**WEST SUSSEX COUNTY COUNCIL
STRATEGIC PLANNING CONSULTATION**

DATE: 19th May 2015

SUBJECT: LU/114/15/RES - Approval of reserved matters following outline permission LU/47/11 for layout, appearance and landscaping of access road.

LOCATION: Land north of Toddington Lane, east of southern section of proposed by-pass and west of parcels B3 and B5, Littlehampton BN17 7PP.

Drawing No. CV8140927/600-2 Rev P2

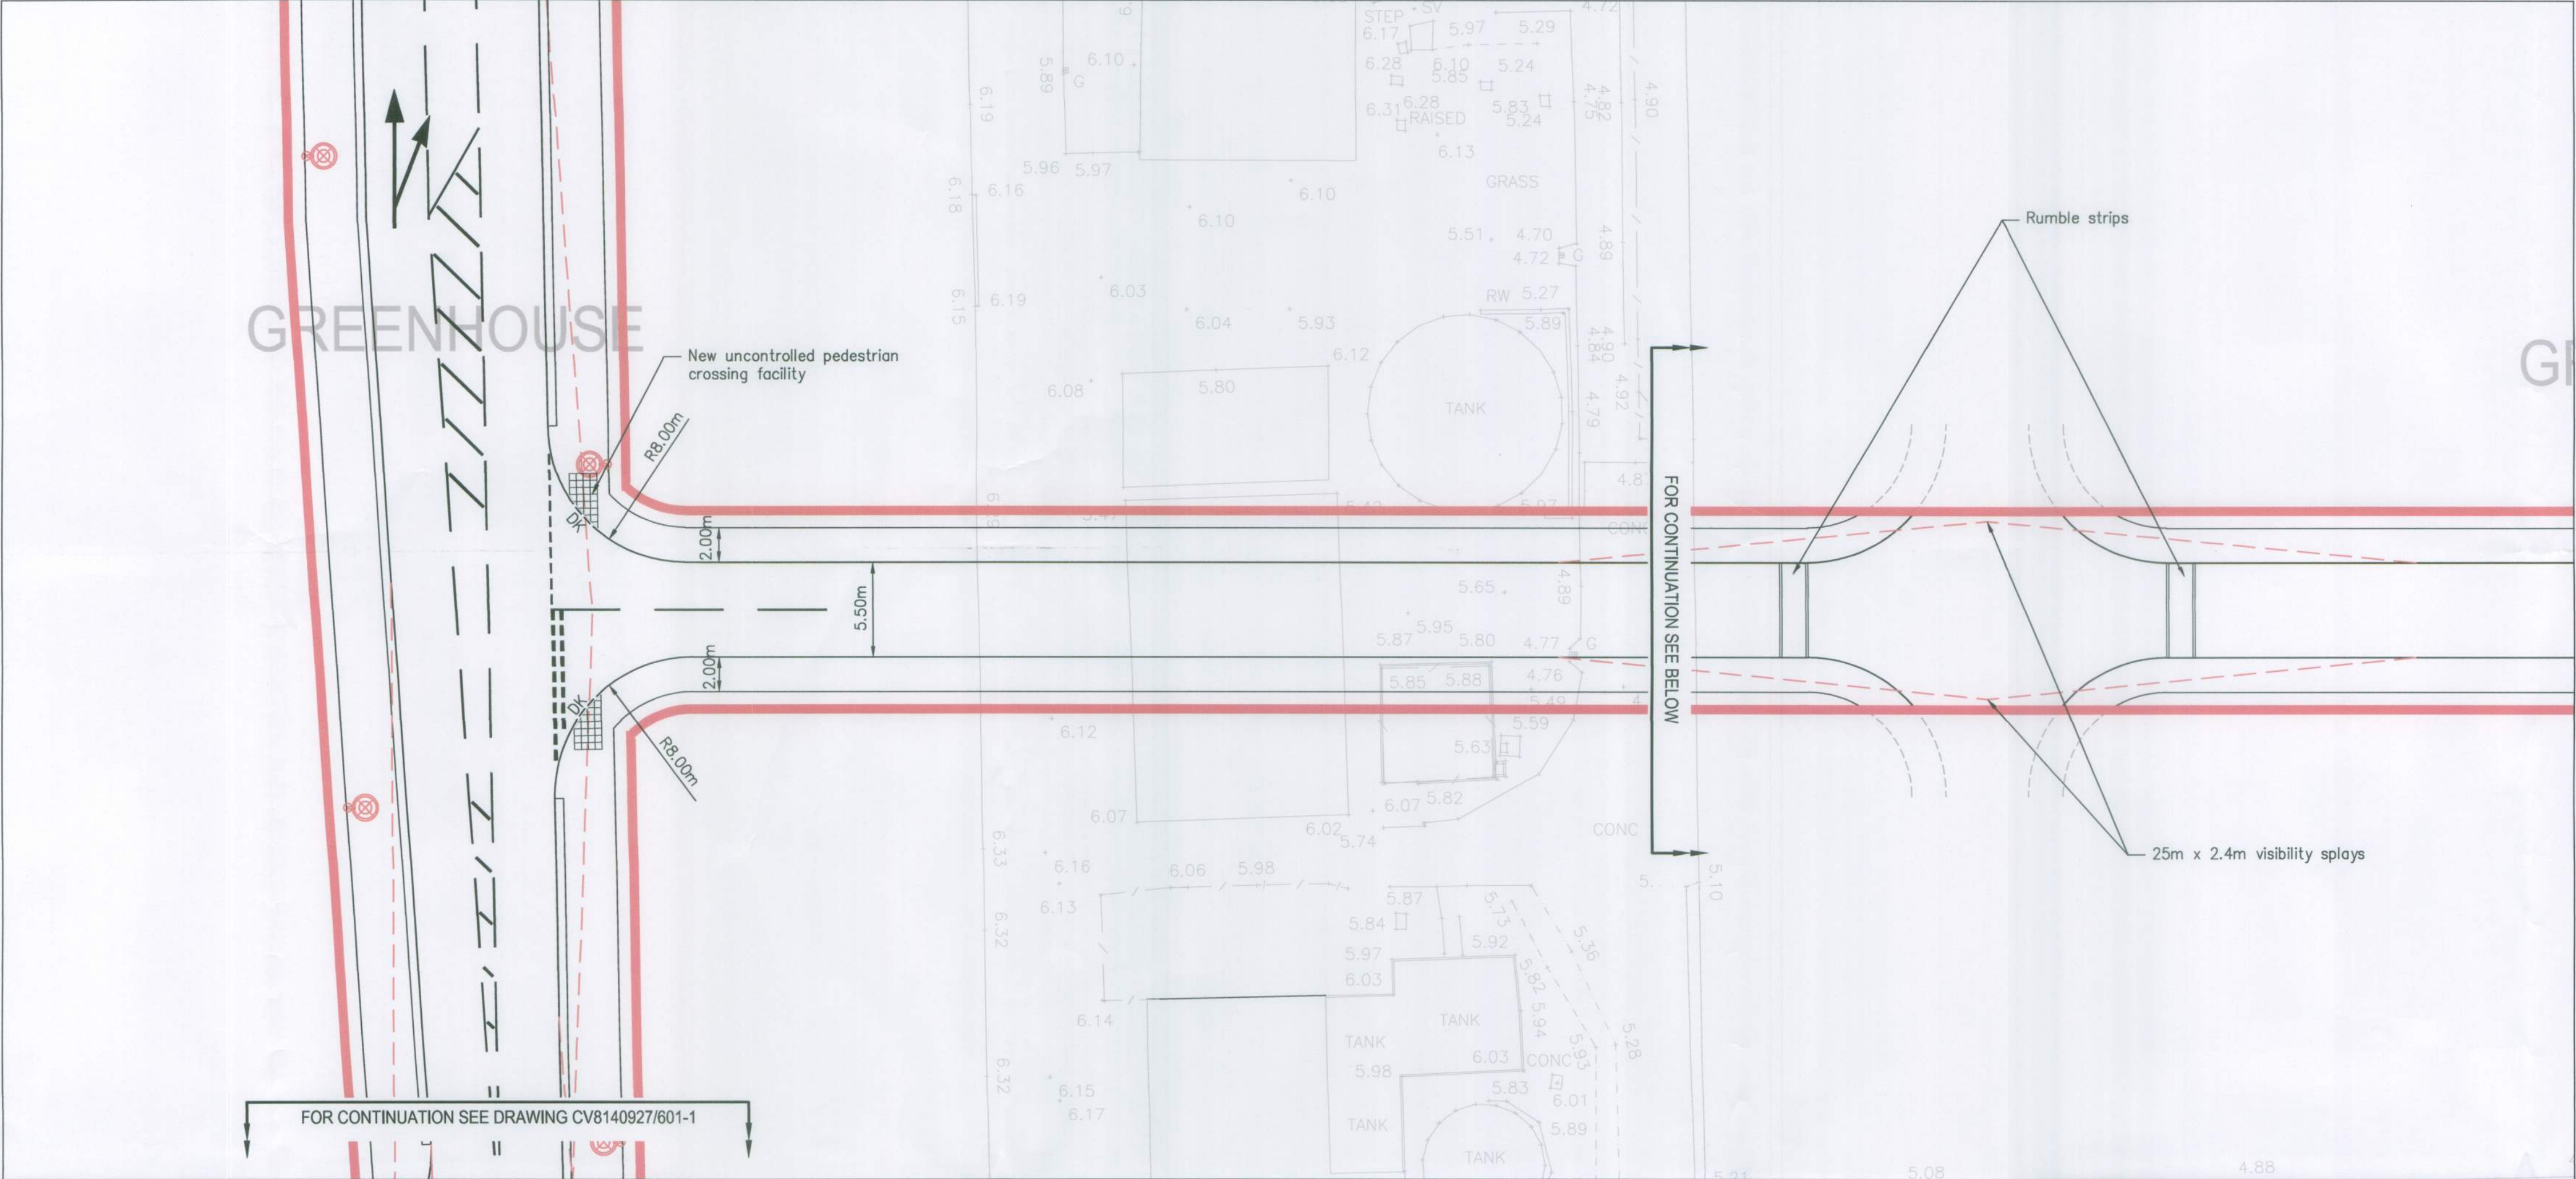
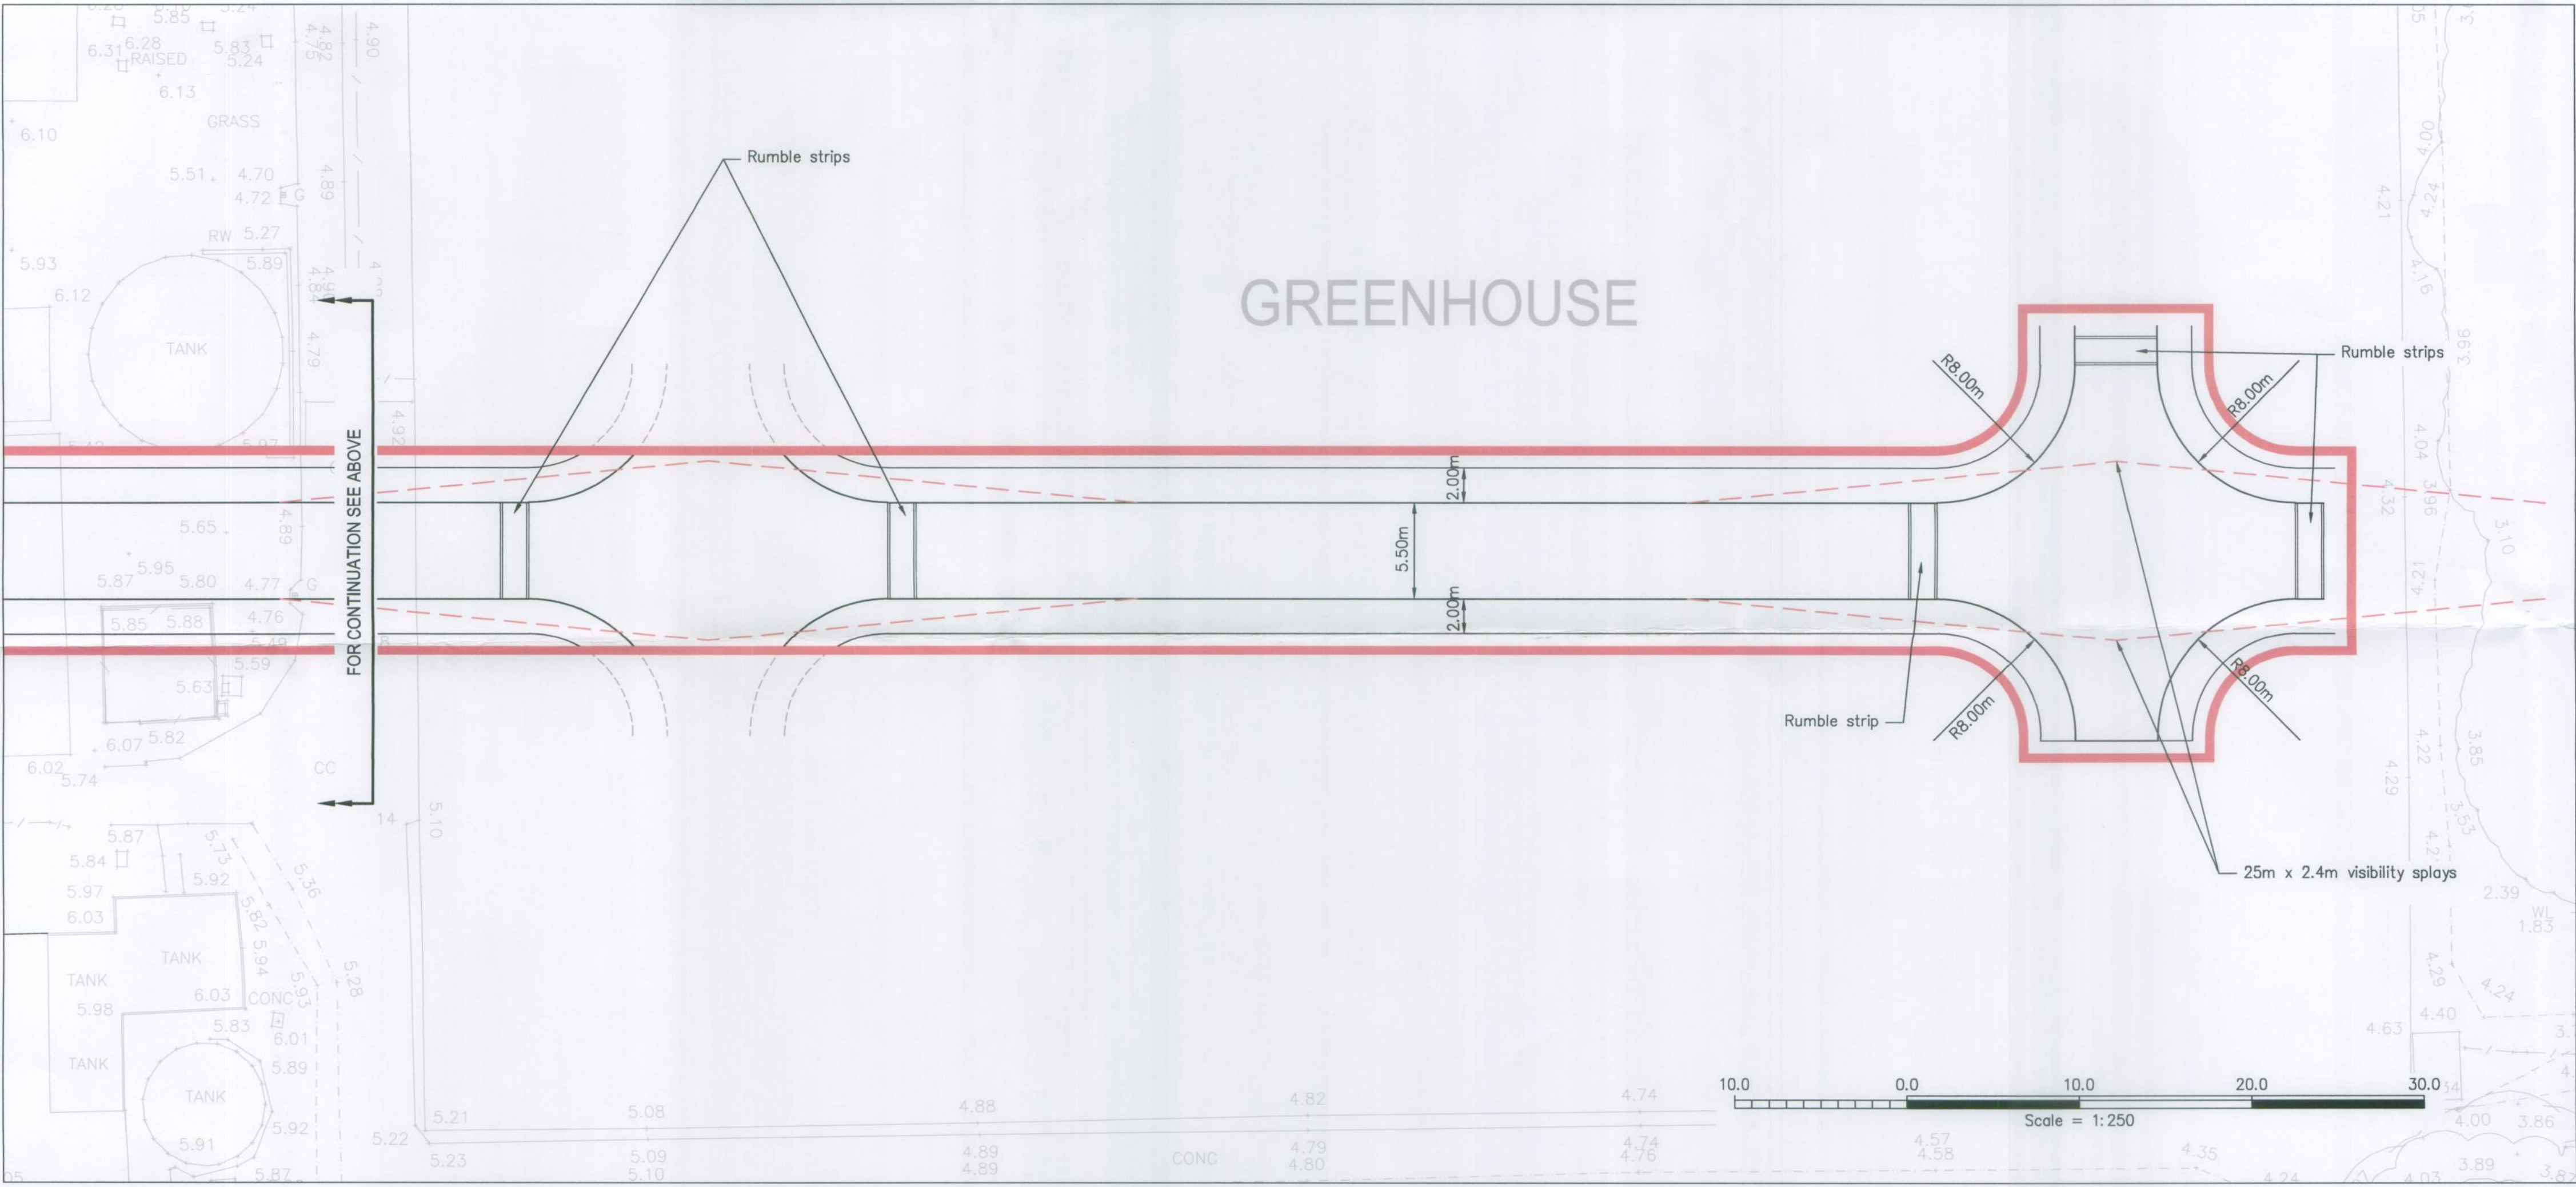
8. Tactile paving (corduroy or similar) to define start and finish of shared footways/cycleways will be considered in detail at S38 stage.
9. For 'crossroad' arrangements on east-west access road, these should be constructed as raised tables in accordance with WSCC standard details. As shown, the rumble strip details are unlikely to provide adequate speed control. Please show.
